Recommendation Report for Planning Permission for Works or Extension to a Dwelling

REF NO: BR/131/21/HH

LOCATION: 78 Orchard Way  
Bognor Regis  
PO22 9HP

PROPOSAL: Dropped kerb

PROPOSED DROP KERB TO 78 ORCHARDWAY BOGNOR REGIS. PO22 9HP. FOR EXISTING DRIVE.

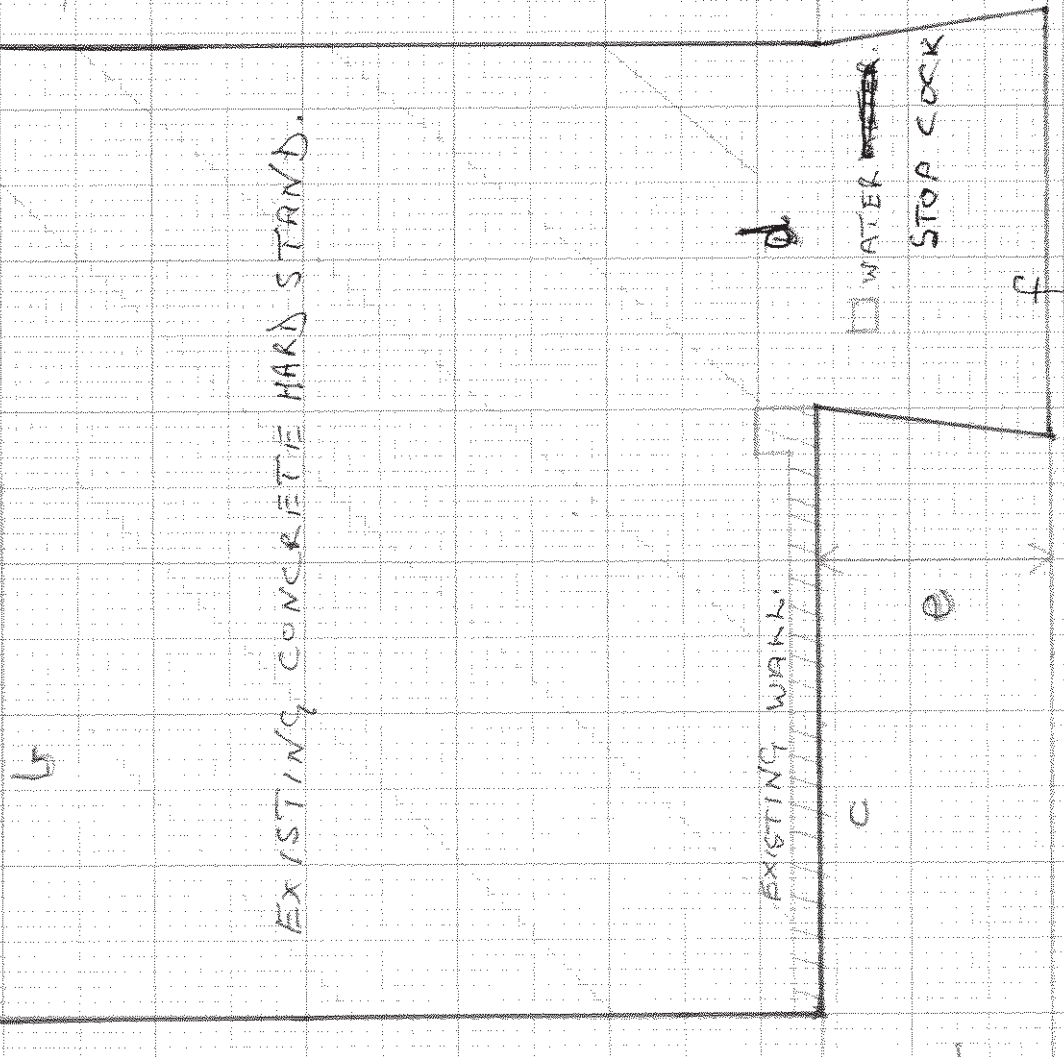
WSCC Highways:  
The dropped kerb will be approximately 5.6m in width. The dropped kerb would be subject to a licence from the WSCC Area Engineer and must be constructed to a specification agreed with them. The proposed plans do not demonstrate visibility at the proposed access onto Orchard Way, however from an inspection of WSCC mapping, visibility appears sufficient for the anticipated road speeds in this location and splays are maintainable wholly within the public highway. The site benefits from an existing hard-standing parking area provision parking for at least three vehicles.

WSCC Highways state the dropped kerb will be approximately 5.6m in width. The dropped kerb would be subject to a licence from the WSCC Area Engineer and must be constructed to a specification agreed with them. The plans do not demonstrate visibility at the access onto Orchard Way, however from an inspection of WSCC mapping, visibility appears sufficient for the anticipated road speeds in this location and splays are maintainable wholly within the public highway. The site benefits from an existing hard-standing parking area provision parking for at least three vehicles. The LHA does not consider that this proposal would have an unacceptable impact on highway safety or result in 'severe' cumulative impacts on the operation of the highway network, therefore is not contrary to the NPPF (para 109 now 111), and that there are no transport grounds to resist the proposal.

- 3 The use of the access shall not commence until such time as the vehicular access serving the development has been constructed in accordance with the approved plan.
